**Transport
for NSW**

Mixed Use Development for Student Accommodation and a Residential Flat Building, 175-177 Cleveland Street, Redfern (SSD 6371)

Thank you for your letter dated 7 July 2014 requesting Transport for NSW (TfNSW) comment on the above development application. Roads and Maritime Services (RMS) will provide its comments separately.

DRAWING NAME
BASEMENT PLAN

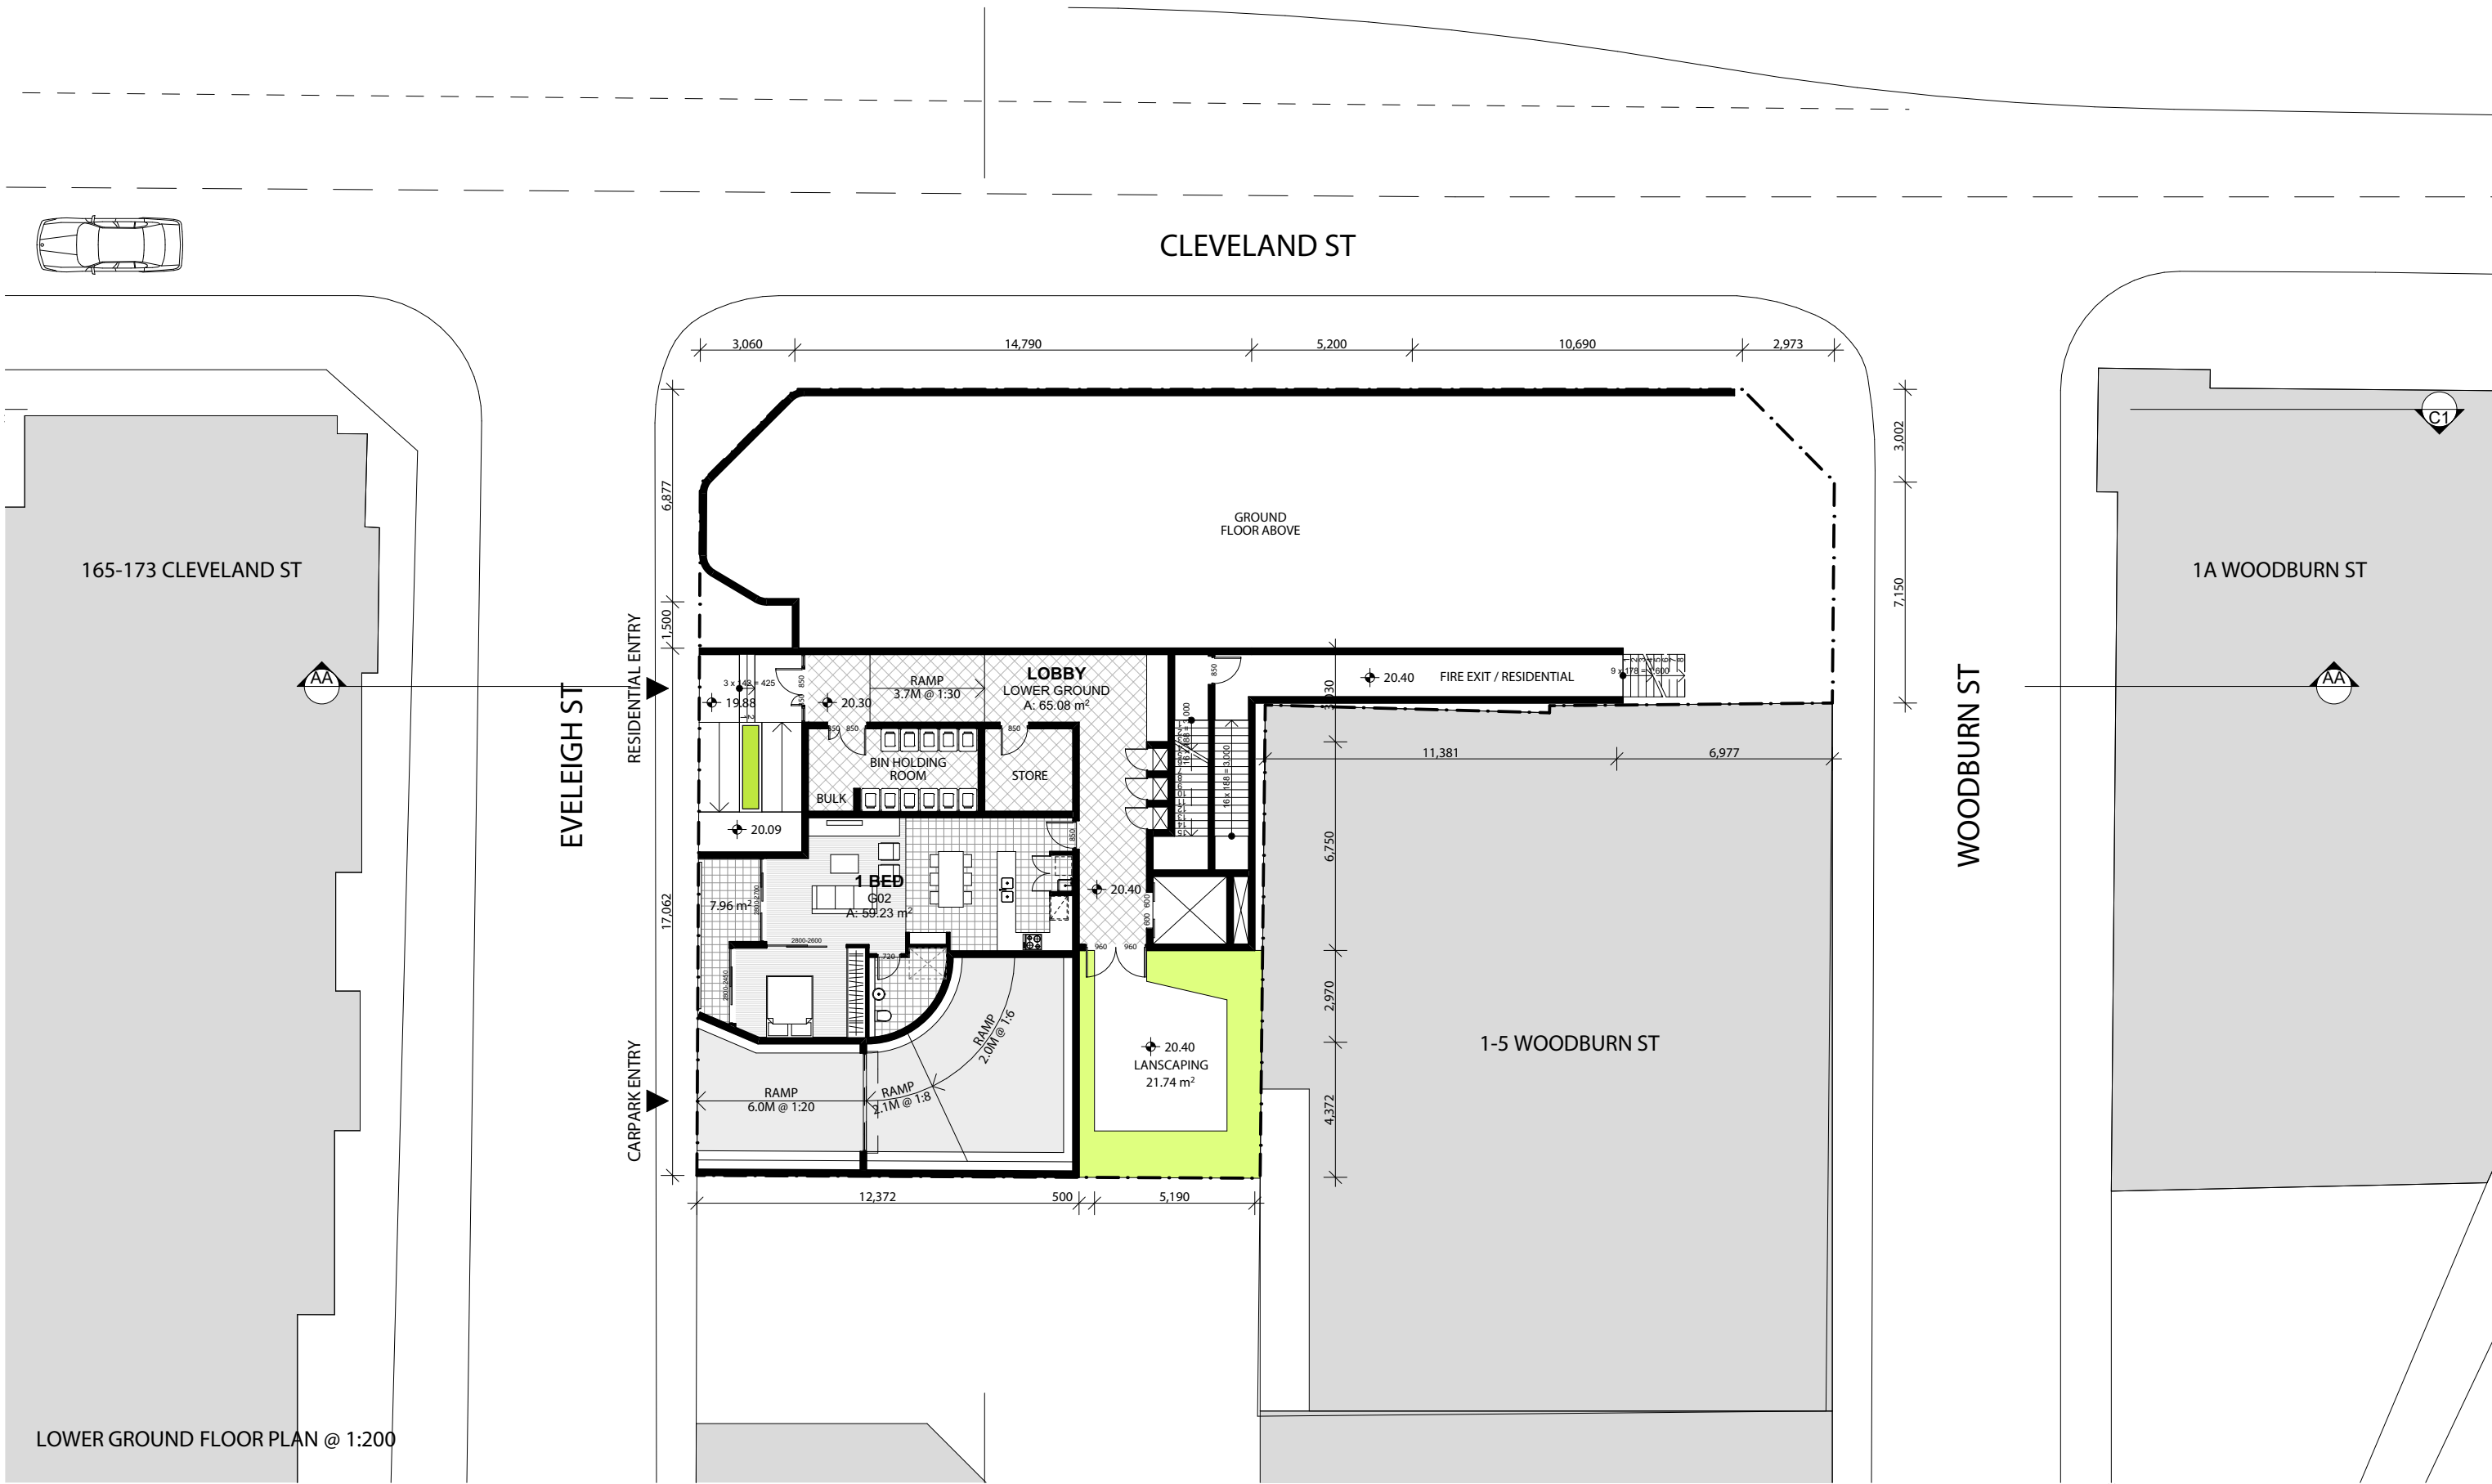
The proposed development provides a total of 21 bicycle parking spaces (13 spaces for residents and 8 spaces for student accommodation based on *Affordable Housing for all Rental Housing 2009*).

TfNSW recommends that at least one bicycle space be provided for each one bedroom residential apartment as well as for each student room. This bicycle provision will contribute to:

Based on the above requirements, TfNSW requests that applicant provides the following bicycle parking:

- Residential apartments – 13 spaces.
- Student accommodation – 40 spaces.
- Administration and managers office – 1 space.
- Visitors parking – 6 spaces (2 space for residential apartments and 4 spaces for student accommodation).

The student bicycle parking provision, in addition to that initially proposed (8 spaces), can be taken up within each individual room should adequate space and provisions be made available. Additionally, all visitor spaces shall be located close to the development entrance in a safe and accessible area.

TfNSW also requests that secure bike parking facilities be provided in accordance with the following:

- Class 1 bike lockers for occupants of residential building.
- Class 2 bike facilities for staff/employees of any land use.
- Class 3 bike rails for visitors of any land use.
